## A303 Sparkford to Ilchester Dualling Scheme TR010036

### 9.1 Responses to the Examining Authority's Written Questions

**Responses to the Examining Authority's Written Questions**

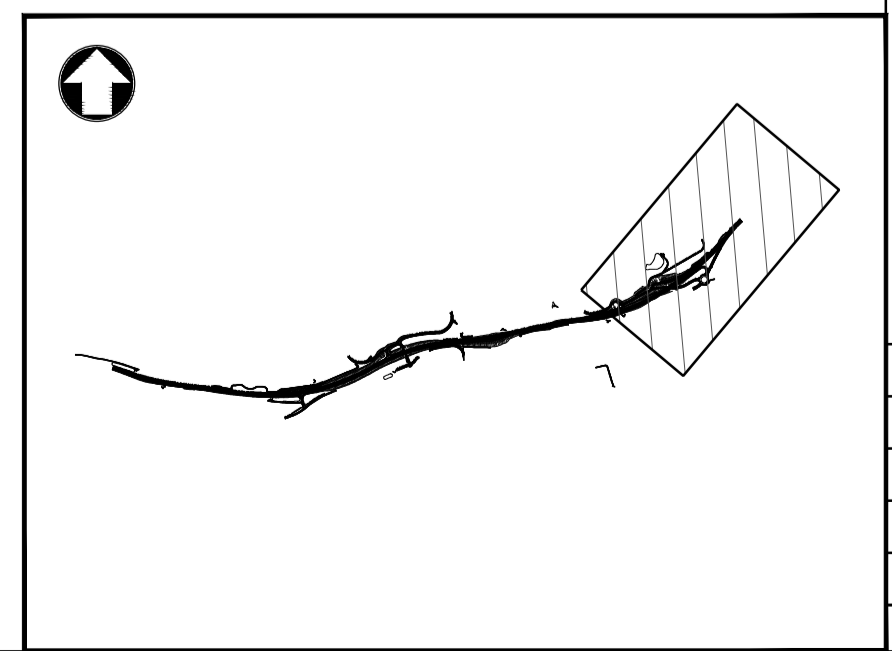
1.1.14.	<p><b>Heritage Assets (generally)(lighting)</b></p> <p>a) Lighting, both constructional and during operation, can be considered a nuisance. However, there is no evidence within the ES Appendix 6.5 Statement Relating to Statutory Nuisance [APP-146] that construction lighting effects have been fully assessed. It is noted that the Cultural Heritage chapter [APP-043] Table 6.4 states that construction lighting will affect the heritage settings of Eyewell House and Hazlegrove House and associated Registered Park</p>	<p>Noted.</p>

Ref	Question:	Question Response
	and Garden (RPG). Furthermore, Table 6.5 states that Hazlegrove House Group heritage setting will be adversely impacted by lighting columns for the first few years. No description of how construction and operational lighting has been assessed or, how the effect has been quantified is included within the ES.	
	Could the Applicant provide a description of the methodology used to determine the significant effects of construction and operational lighting on the heritage assets, with particular reference to Eyewell House, Hazlegrove House Group, and Hazlegrove Group RPG?	The methodology to determine impacts of constructional and operational lighting uses Conservation Principles, Practice and Guidance (Historic England) and Historic Environment Good Practice Advice in Planning Note 3: The Setting of Heritage Assets (Historic England). Guidance used is noted in section 6.4, paragraph 6.4.3 in Chapter 6 of the Environmental Statement, Cultural Heritage, and Section 3.4, Paragraph 3.4.1 of Appendix 6.1 Cultural Heritage Desk Based Assessment (APP-067) of the Environmental Statement.

b) Could the Applicant please indicate how long "the first few years" referred to above would be?	The operational lighting at Hazlegrove Junction will be screened from the Hazlegrove House Registered Park and Garden (RPG) by year 15.
	<b>Heritage Assets (generally) (landscape and visual effects)</b>
